**KIRKLEES METROPOLITAN COUNCIL
INVESTMENT & REGENERATION SERVICE**

DELEGATED DECISION TO DETERMINE PLANNING APPLICATIONS

Reference No:	2025/62/90756/E
Site Address:	Sir Robert Peel Inn, 14, High Street, Heckmondwike, WF16 0AR
Description:	Alterations to convert former public house to 6 flats
Recommending Officer:	Nina Sayers

**SITE LAYOUT & LOCATION PLAN
1.200 & 1.500**

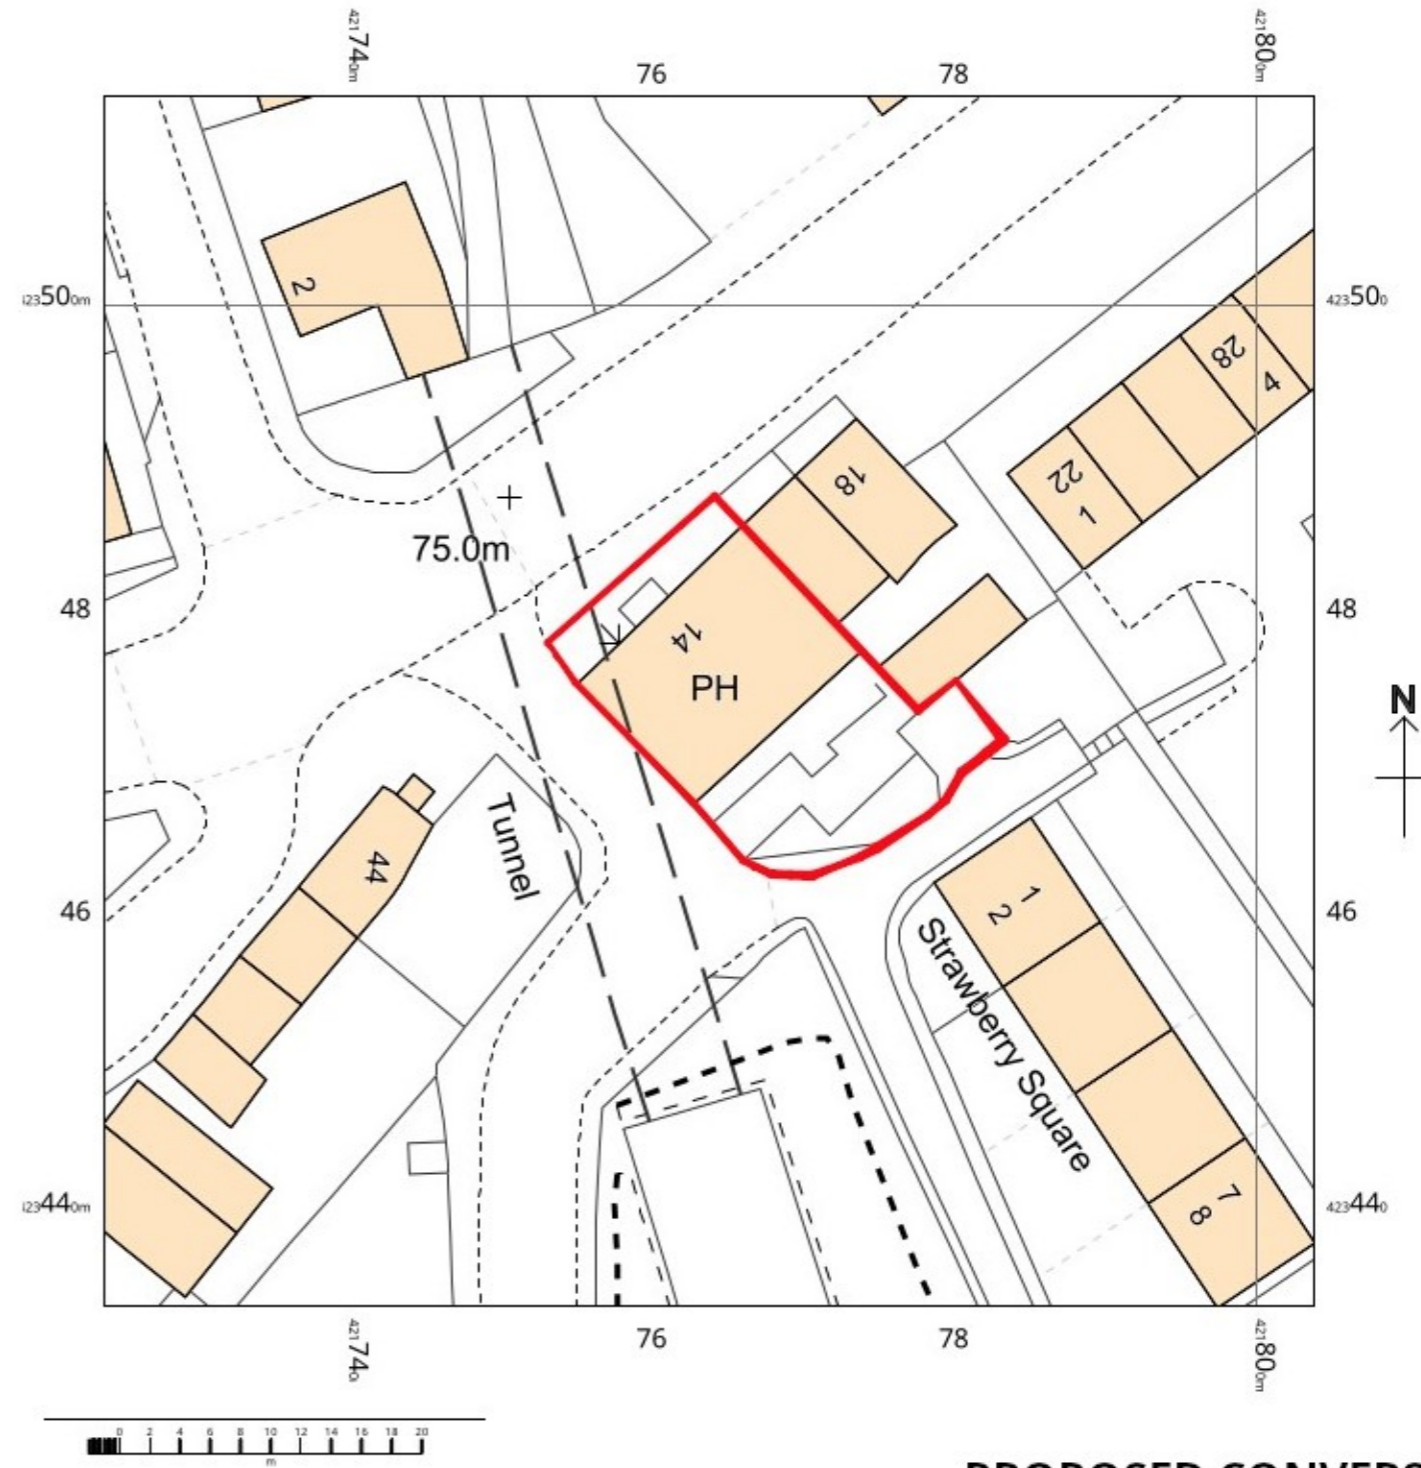
An amended site plan was sought to remove reference to the proposed parking to the rear as this was a point of concerns for officers as discussed in detail in section 4 of this report. Amended plans were received. No re-advertising was considered necessary as this appeases a number of the representations received.

The scheme initially proposed 6 parking spaces, 2 of which are existing. 4 spaces were proposed to the rear of the property fronting Strawberry Square. KC Highways Development Management raised concerns as the road to the rear is narrow and would not provide adequate manoeuvrability for vehicle turning, particularly due to the location of the existing telegraph pole. Further to this point, it was noted that the retaining structure that would need to be erected to support the parking could have the potential to impact on the stability of the adjacent highway and any light and outlook to the openings to the rear of the property.

The application site is within a sustainable location, <25m from Heckmondwike Town Centre and located on High Street which has frequent buses to Dewsbury, Cleckheaton and Bradford. On this basis, and due to the concerns raised in regards to the additional parking provision, officers requested that the additional parking provision be removed from the scheme. Amended plans were received which retained the 2 existing parking spaces which is considered acceptable given the sustainable location of the property.

Officer response: This parking element has been removed from the scheme.
